**City of Portland, Maine - Building or Use Permit Application**

<b>Permit No:</b> 2013-00186	<b>Issue Date:</b>	<b>CBL:</b> 166 B012001
---------------------------------	--------------------	----------------------------

**Proposed Project Description:**  
Amendment to permit 2011-10-2535 - adding 42" x 65" landing and stairs on left side.

<b>Dept:</b> Zoning	<b>Status:</b> Approved	<b>Reviewer:</b> Ann Machado	<b>Approval Date:</b> 02/04/2013
<b>Note:</b> Side landing and stairs is being approved under section 14-425. The proposed landing encroaches 1.5' into the side setback. The footprint is 19 sf and it extends 3.5' off the building.			<b>Ok to Issue:</b> <input checked="" type="checkbox"/>

42"x42" Platform and Stairs

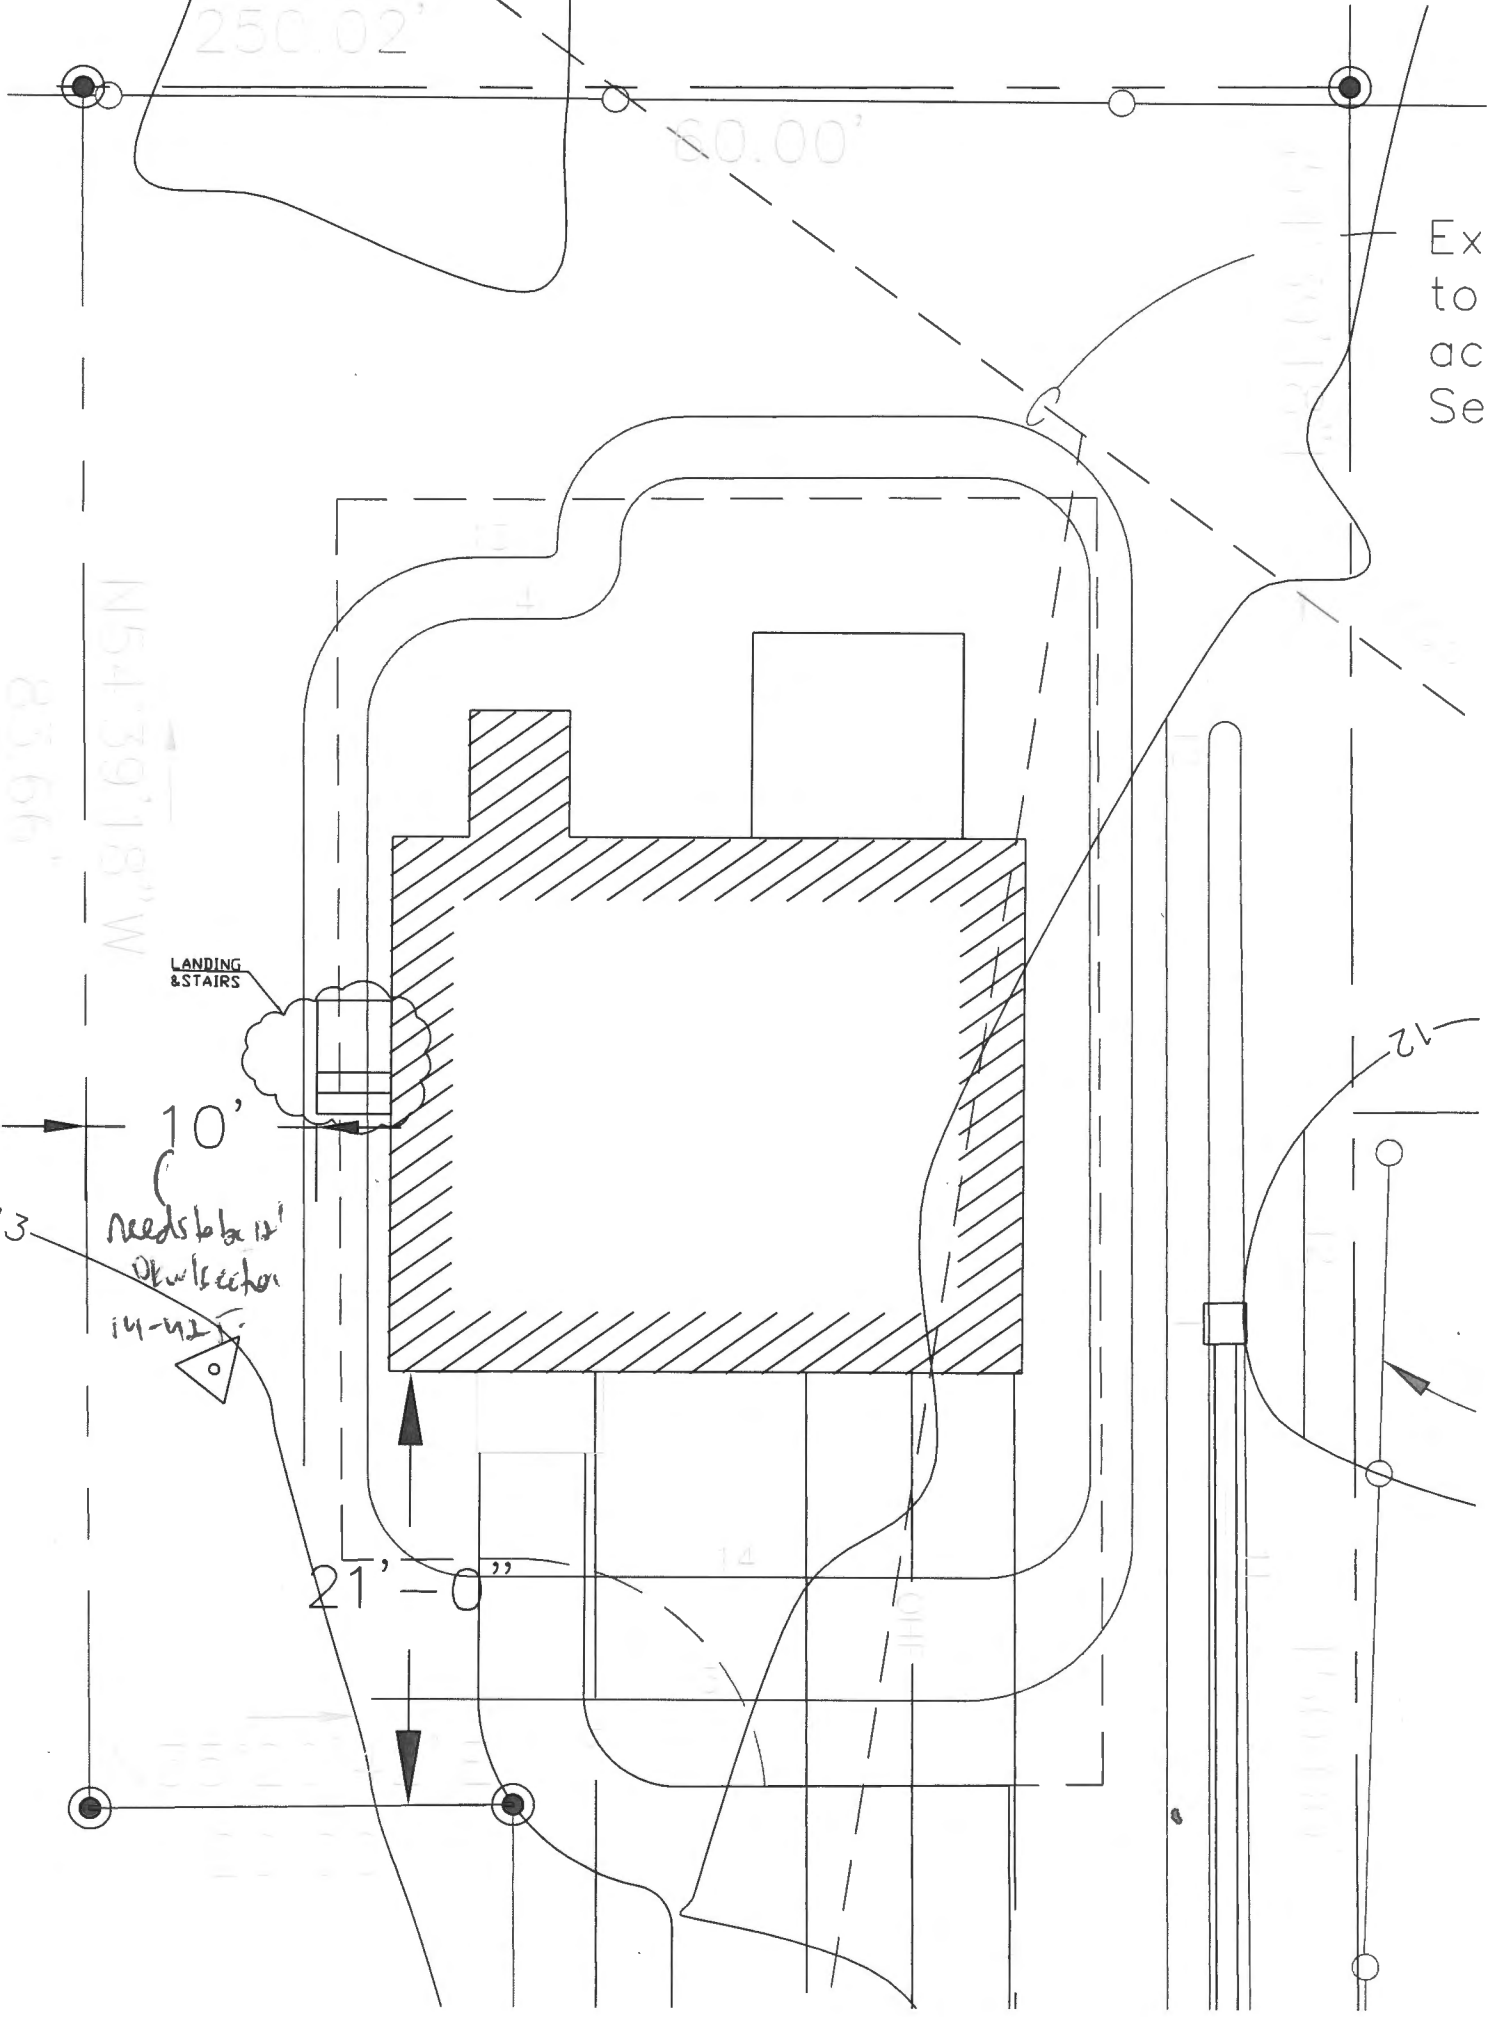
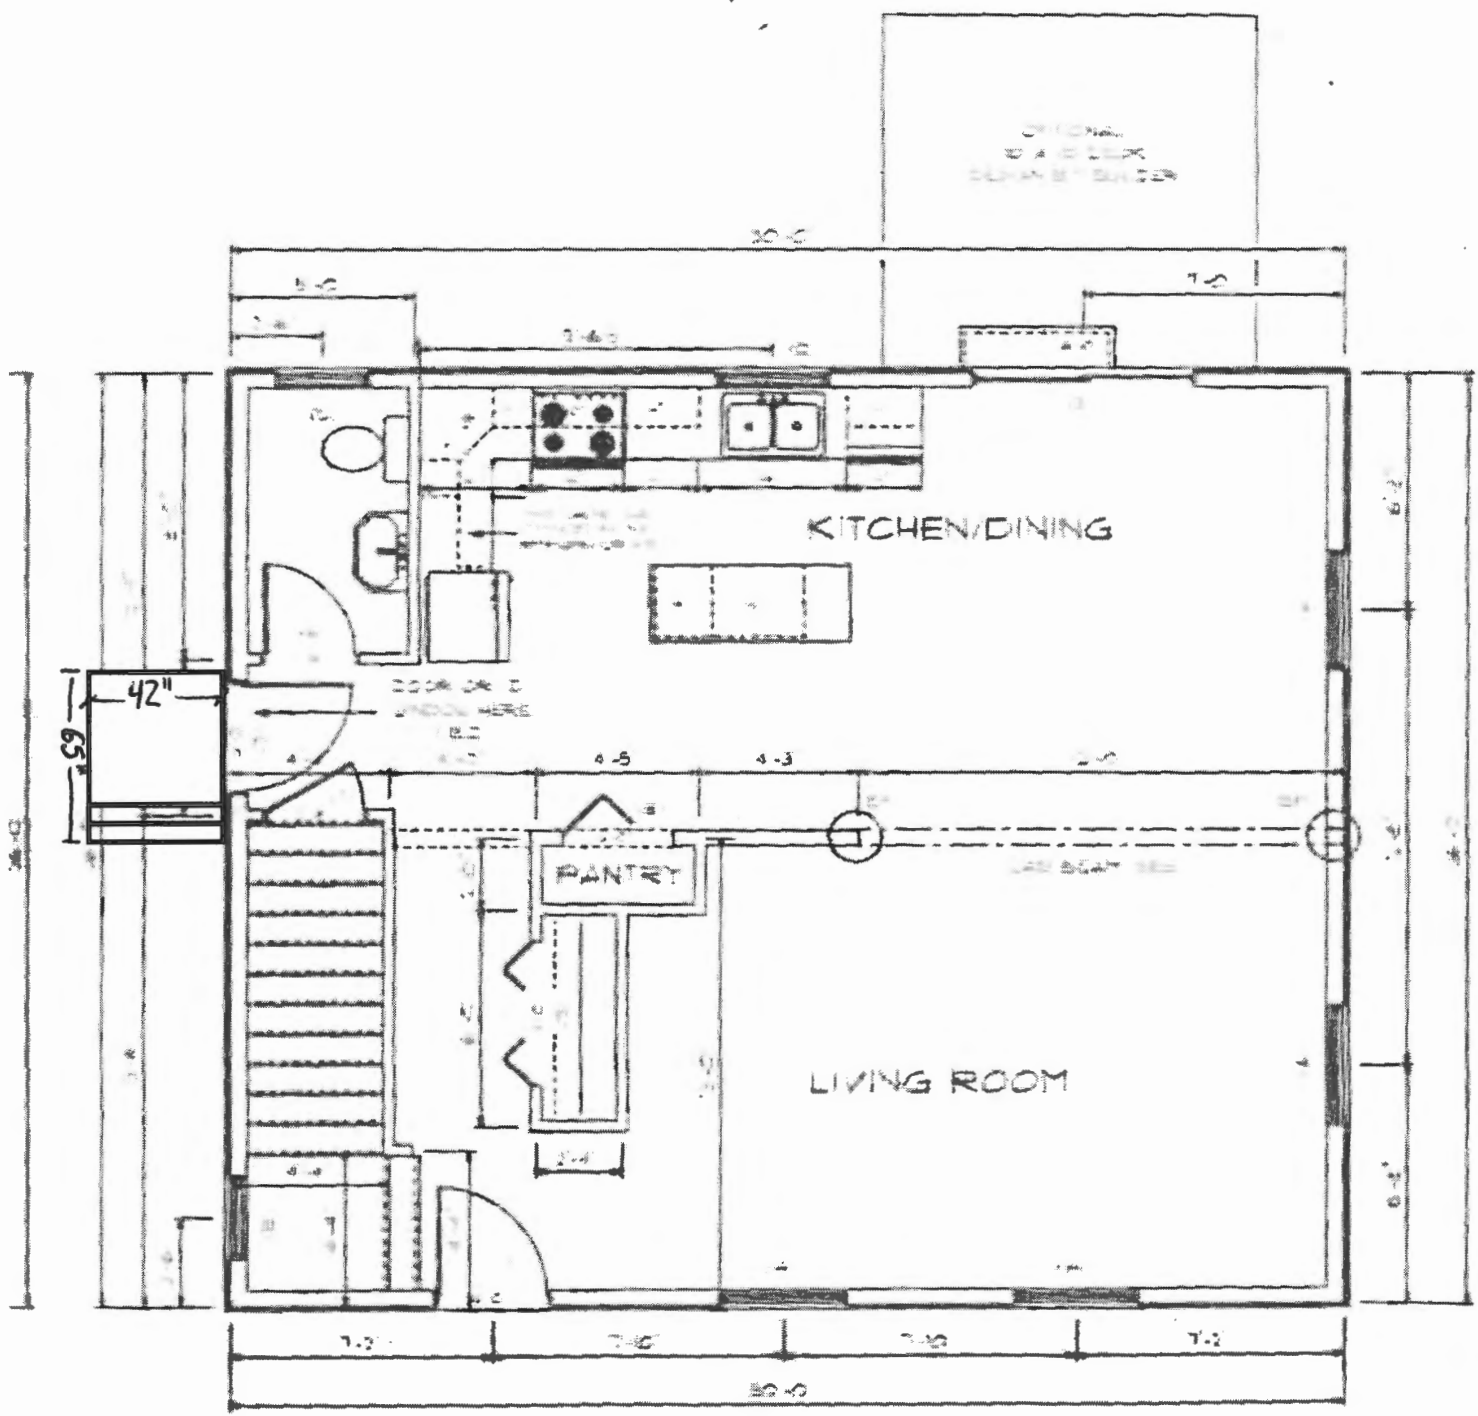
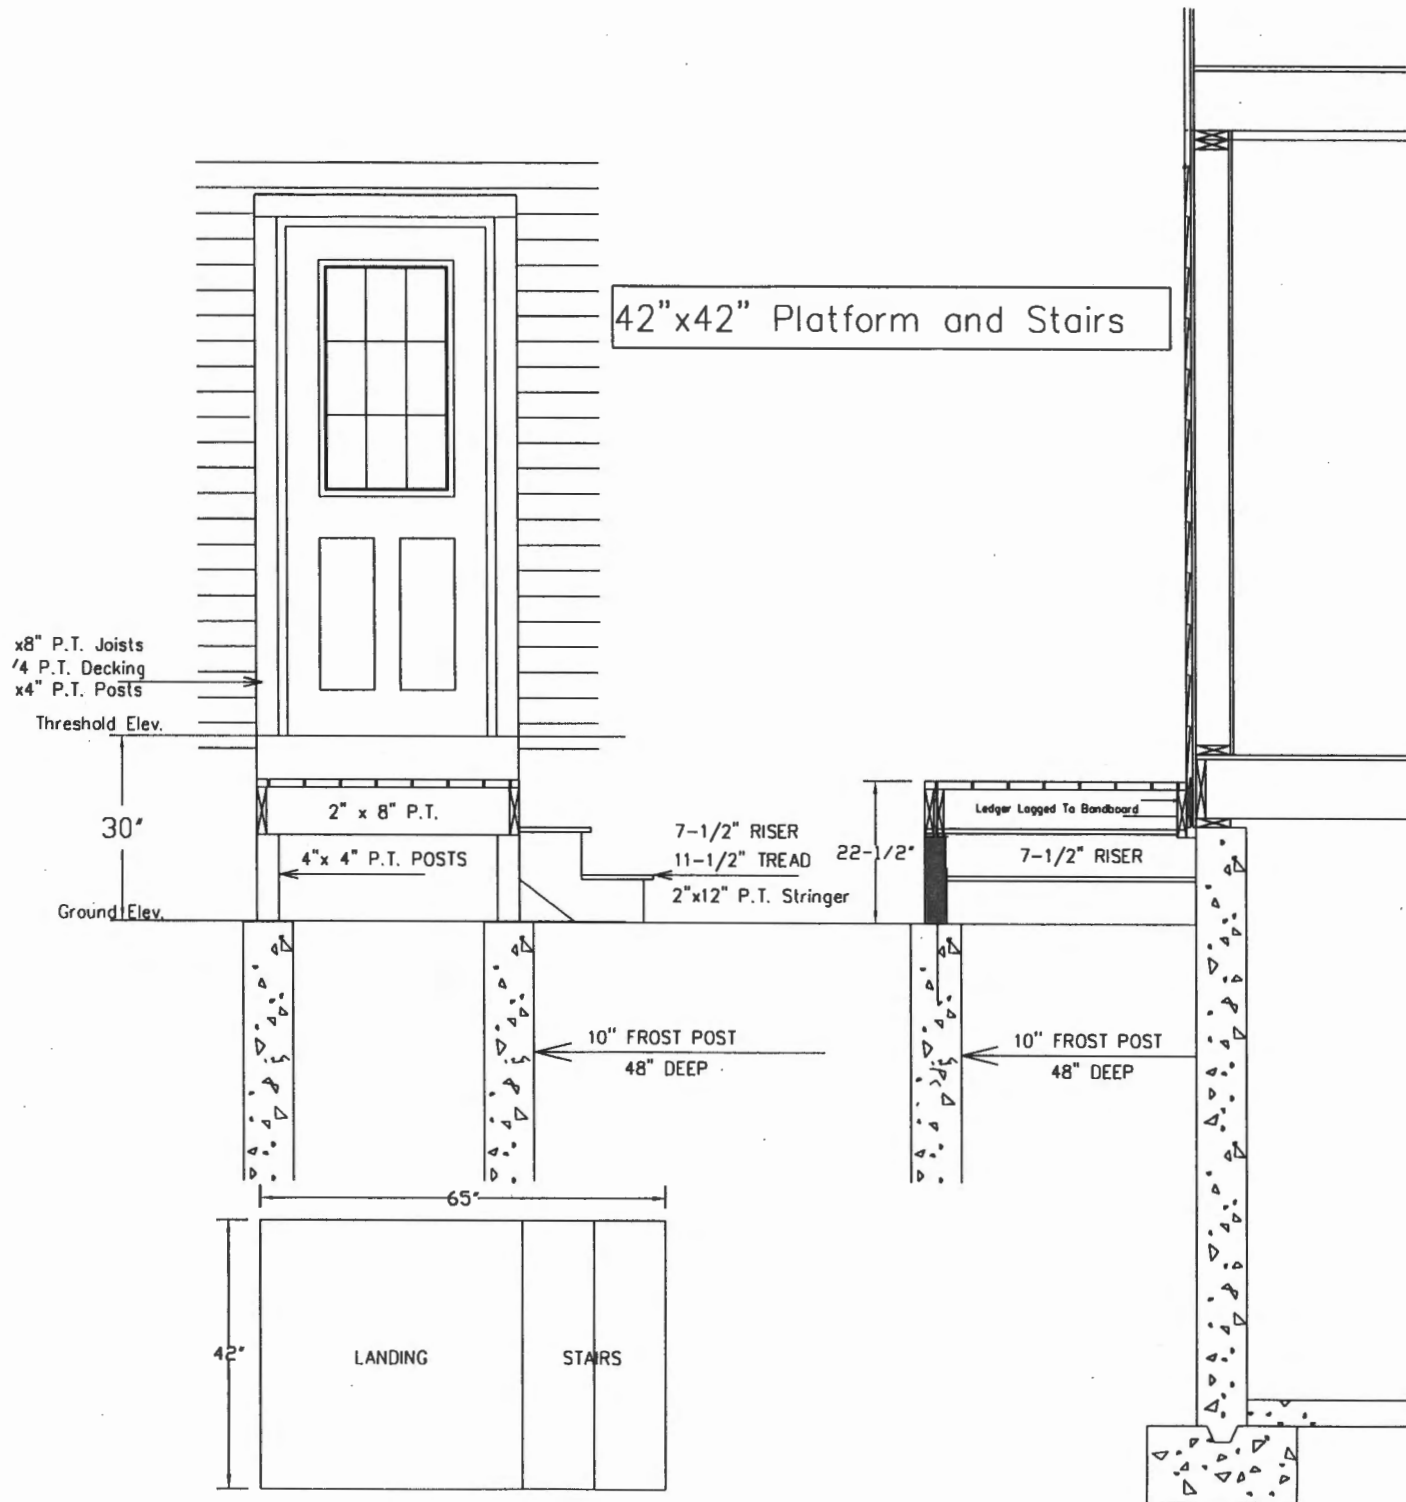
<b>Dept:</b> Building	<b>Status:</b> Approved w/Conditions	<b>Reviewer:</b> Jon Rioux	<b>Approval Date:</b> 02/05/2013
<b>Note:</b>			<b>Ok to Issue:</b> <input checked="" type="checkbox"/>
<ol style="list-style-type: none"> <li>1) R502.6 Bearing. The ends of each joist, beam or girder shall have not less than 1.5 inches of bearing on wood or metal and not less than 3 inches on masonry or concrete except where supported on a 1-inch-by-4-inch ribbon strip and nailed to the adjacent stud or by the use of approved joist hangers.</li> <li>2) R312.3 Opening limitations. Required guards shall not have openings from the walking surface to the required guard height which allow passage of a sphere 4 inches in diameter.</li> <li>3) A graspable handrail (34-38 inches in height) shall be provided on at least one side of each continuous run of treads or flight with four or more risers. Fall protection (36 inches) from exterior decks may be required if floor joist are at or above thirty (30) inches from grade.</li> <li>4) Separate permits are required for any electrical: plumbing, sprinkler, fire alarm, HVAC systems, commercial hood exhaust systems and fuel tanks. Separate plans may need to be submitted for approval as a part of this process.</li> </ol>
